DECISION DELEGATED TO DEVELOPMENT MANAGER

Application No: H23-0953-19 **Applicant:** Mr & Mrs B Adam
Proposal: First floor side extension and two-storey rear extension
Location: 3 Stockwell Gate Whaplode Spalding
Terminal Date: 15th November 2019

DRAWING:
PROPOSED FLOOR PLANS & ELEVATIONS

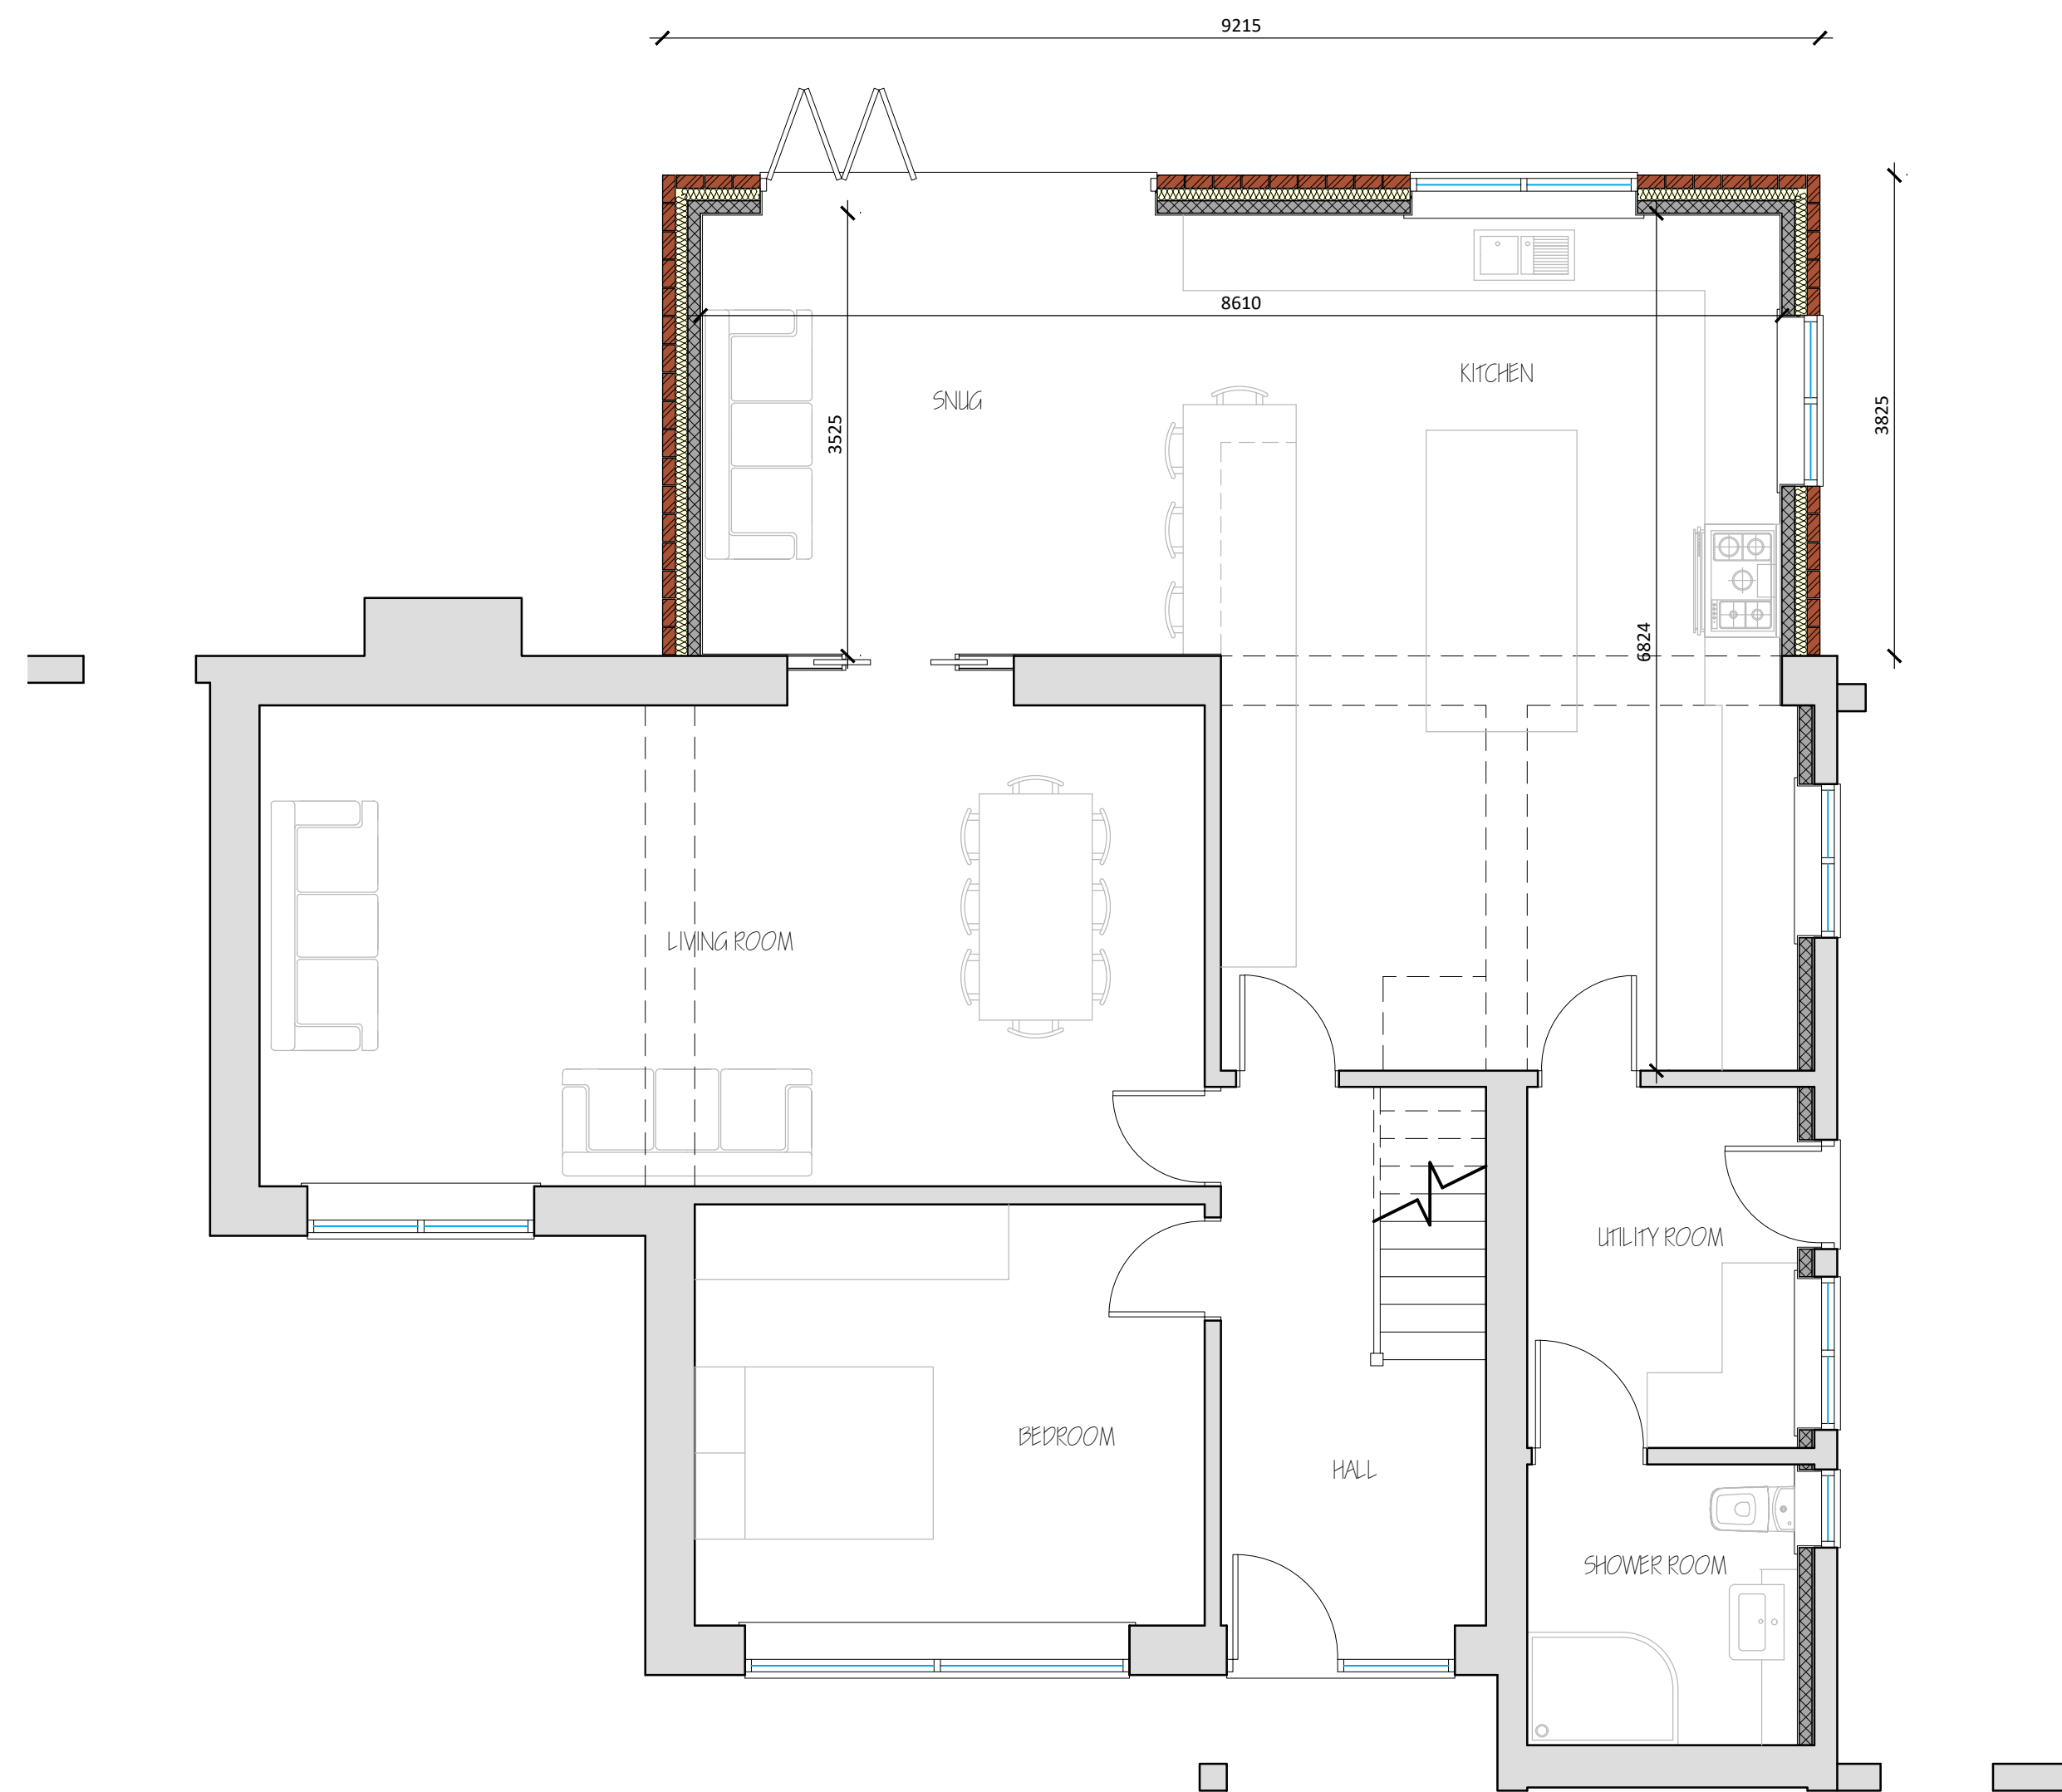
The proposed plans will be increasing the overall footprint of the dwelling by extending to the rear. The rear extension to the ground floor will increase the kitchen size, and create a kitchen/dining area.

There will be a considerable change to the first floor of the dwelling, including the construction of two new bedrooms, along with two en suites and a family bathroom. This will increase the bed room number from 4 to 6 bedrooms.

All of the materials used will match the existing. The overall proposed design of the extension appears to blend in well with the existing dwelling, by creating two new gable roofs to the rear, which will not have a significant impact upon the change in appearance to the property.

The new window on the first floor on the western elevation is considered acceptable and is within a substantial separation distance of 16.4m (Approx.) between the neighbouring property.

The proposed first floor extension to the side of the property will extend by approximately 2.5m, which is no wider than the existing single storey side projection at ground floor.

The new rear extension will be extending out approximately by 3.8m both ground floor and first floor. This proposed extension is in scale with the existing property and is also in scale when you consider the size of the plot. There would be approx. 5m and 7m from the western and eastern boundaries respectively and the rear garden would still be approximately 18m long. Therefore this is acceptable.

The proposed plans show that the ground floor will have bi-fold doors to the rear ground floor extension, as well as windows to the rear and west of the property. These would have a positive impact on the residential amenity of the occupants of the dwelling as it will increase the natural daylight into the property.

The first floor windows include a French door Juliet Balcony, along with two bathroom windows all facing the rear of the property. These will slightly be overlooking to the rear end of the garden of the property known as Silver Birch but this would not have a material adverse impact due to the large separation distance (18+ metres) and the windows will mostly be overlooking onto an open field which is therefore acceptable. Bathroom windows are also typically obscure glazed.

Two new bedroom windows are proposed on the eastern elevation at first floor and a new window for a bedroom on the western elevation. The new windows on the eastern elevation would be at

somewhat of an oblique angle to the adjacent property in that direction and the closest windows on that property would belong to a kitchen and bathroom. The new window on the western elevation would also be at an angle to the adjacent dwelling. Overlooking is therefore not considered to be an issue.

The dwelling is located within a sizeable plot and the distances from adjacent dwellings means that the proposed development should not be overbearing in nature or cause a material loss of light to any other property.
